August 25, 2016

SUBJECT: **Request for Modification to Section 404 Individual Permit and Section 401 Individual Water Quality Certification** for the proposed extension of SR 3000 (Idols Rd.) from SR 2999 (Hampton Rd.) to US 158 (Clemmons Rd.), Forsyth County. Federal Aid Project No. STP-3000 (1), State Project No. 8.2624101, T.I.P. Project No. U-2707. Debit \$570.00 from WBS Element No. 34845.1.1.

REFERENCE: Individual Permit Application dated May 4, 2012.
Section 404 Individual Permit issued November 5, 2012.
Section 401 Individual Water Quality Certification issued August 6, 2012.

Permit Drawing Sheet 8 of 15
Revised 8/24/2016

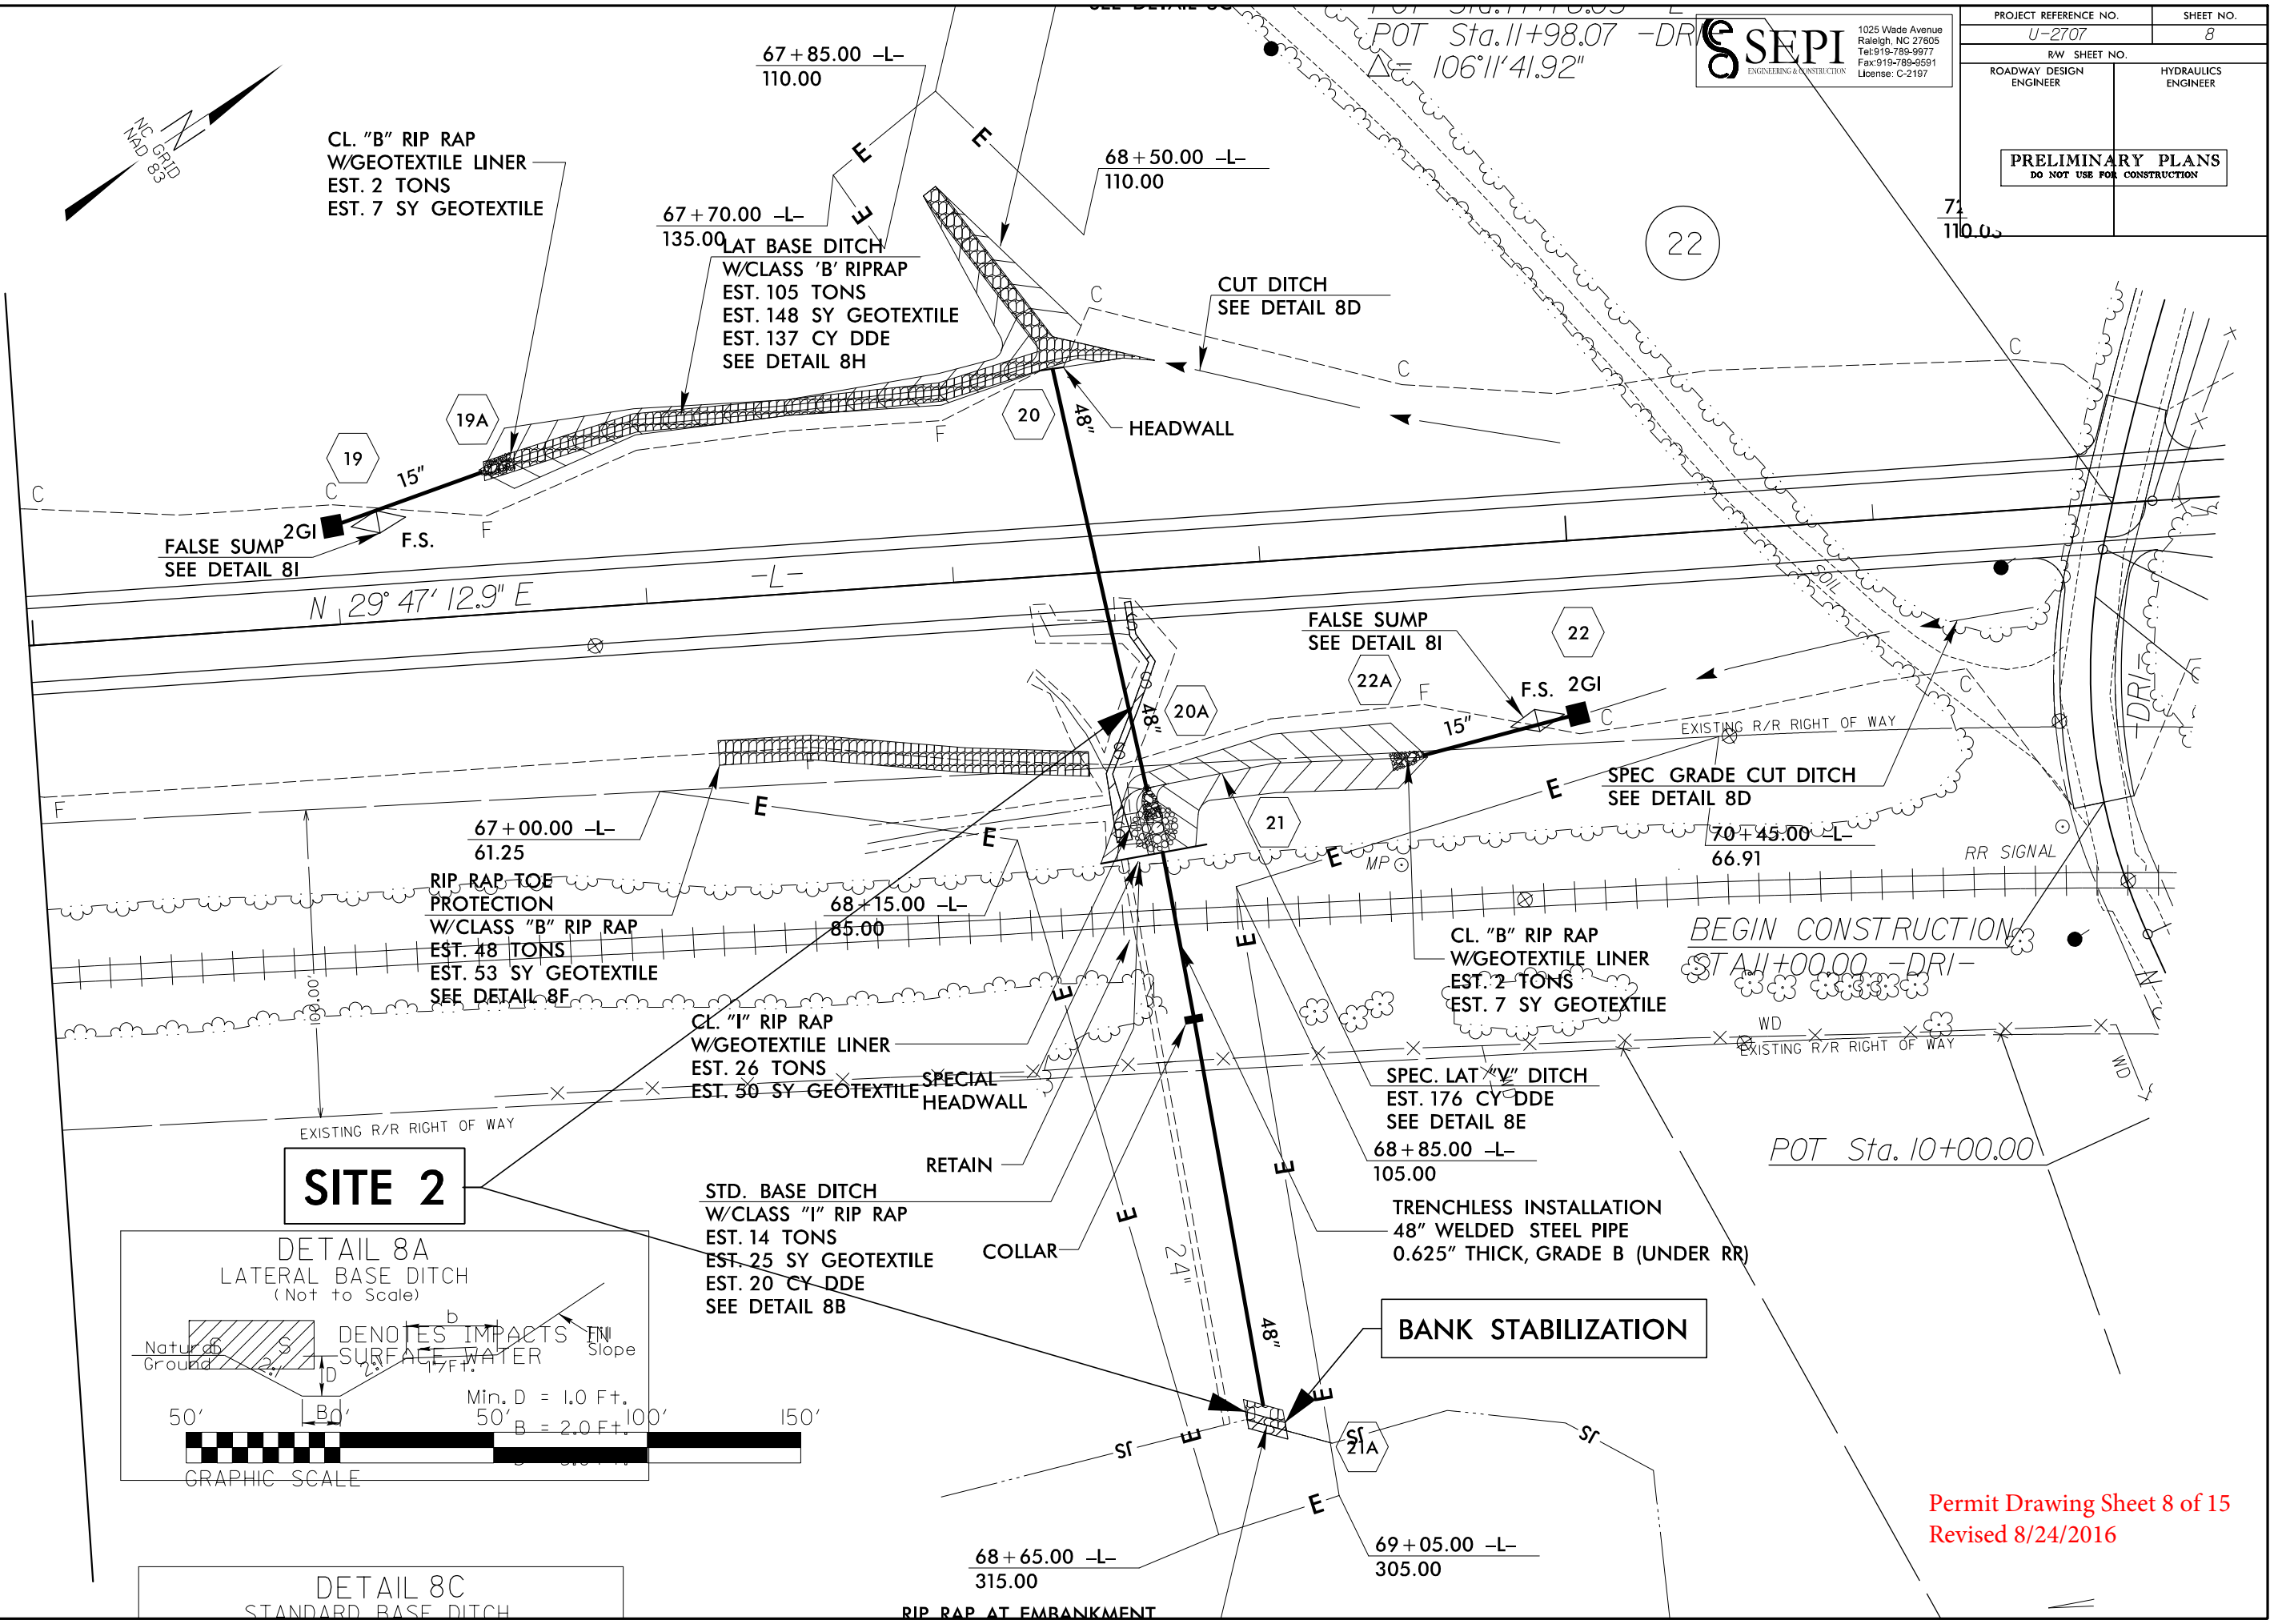
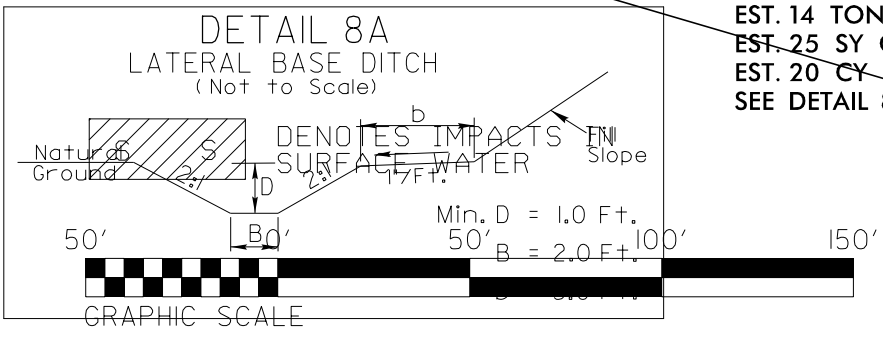
The original permit application dated May 4, 2012, stated the impacts at Permit Site 2 are from the relocation of a jurisdictional stream into a series of two new 48" pipes. Permanent impacts from 14 lf of bank stabilization at the outfall of the second 48" pipe were not included in the original submittal (See Revised Permit Drawing Sheet 8 - attached). The receiving stream below the 48" pipe was not depicted on the original permit drawings but will not be impacted by this action. Permit Site 5 had no impacts in the original submittal. A damaged pipe was to be replaced with a pipe with baffles to enhance fish passage and this enhancement would offset any permanent impacts. The damaged pipe will now be removed without replacement. A 48" temporary pipe will need to be installed at the same location for a temporary crossing for equipment access in the construction of the bridge to the south. Temporary impacts of <0.01 acre

Permit Drawing Sheet 10 of 15
Revised 8/24/2016

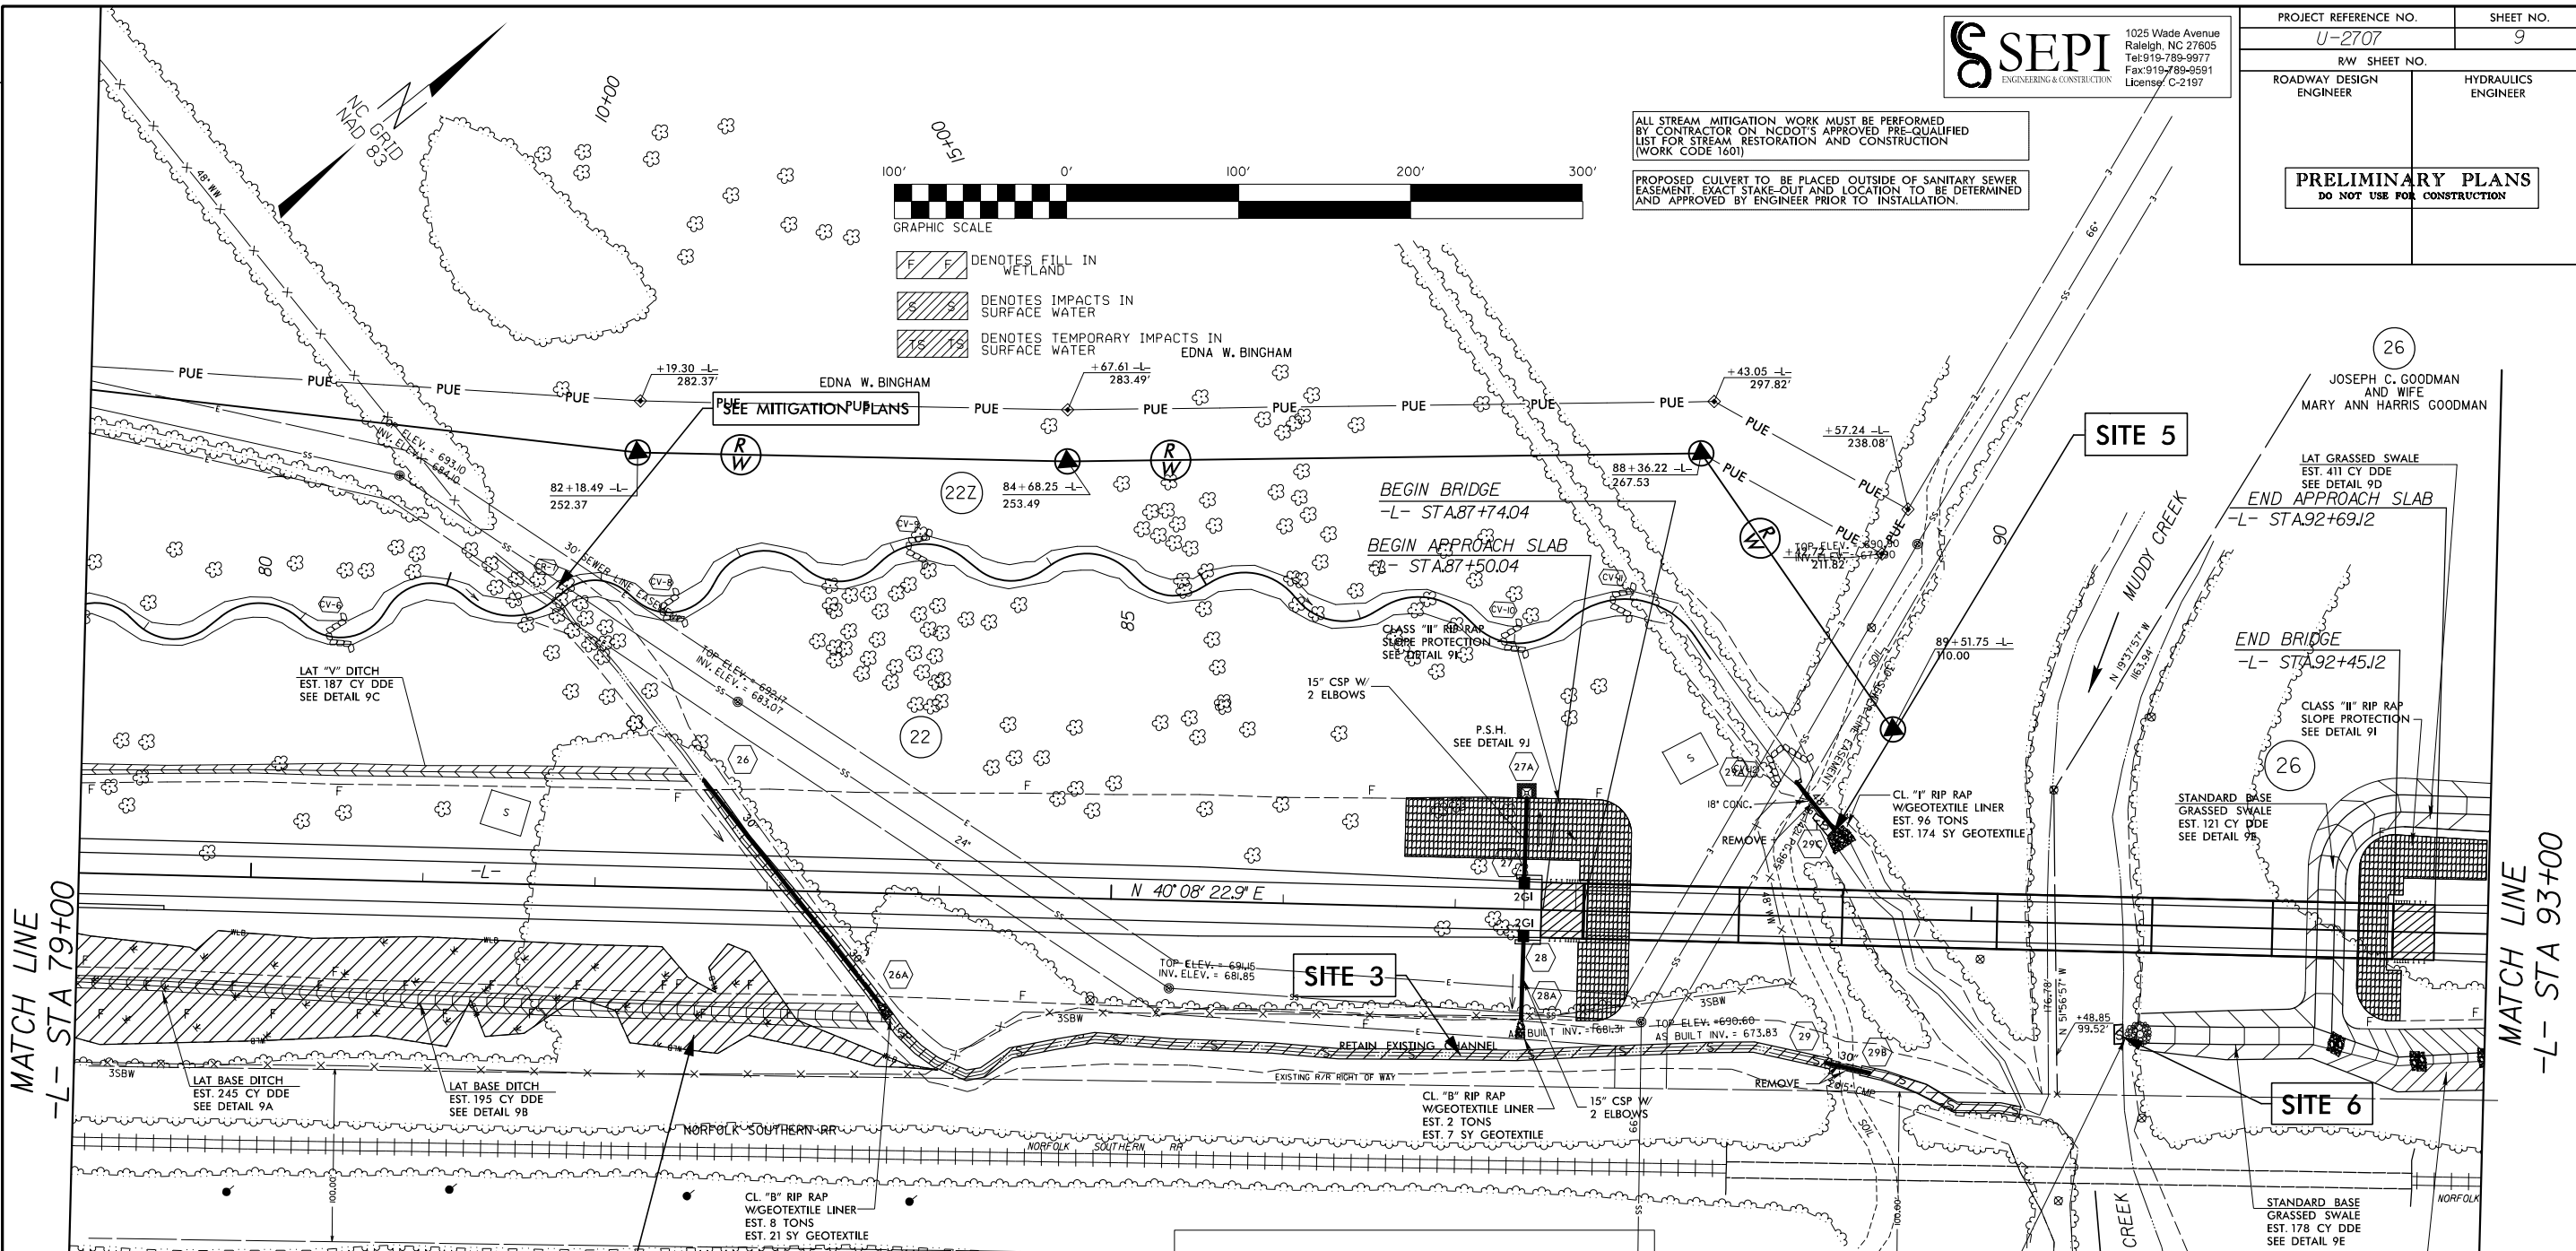
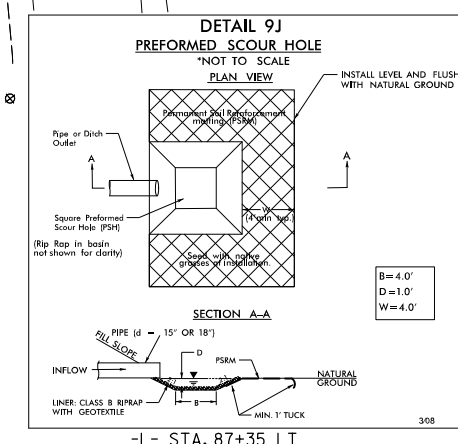
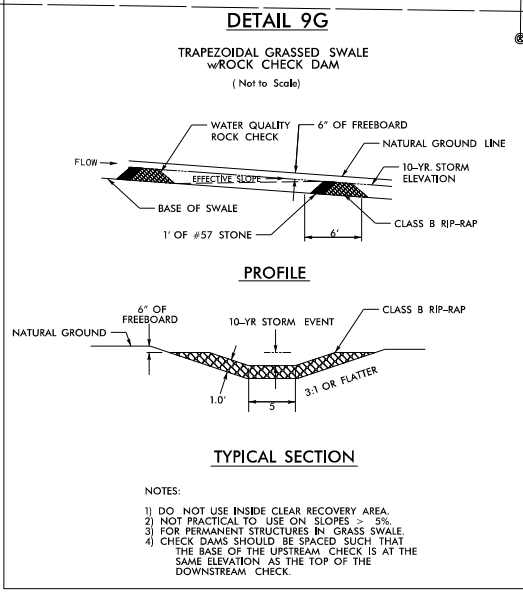
(50 lf) will result from this action (see Revised Permit Drawing Sheet 10 and the Revised Impact Summary Sheet - attached).
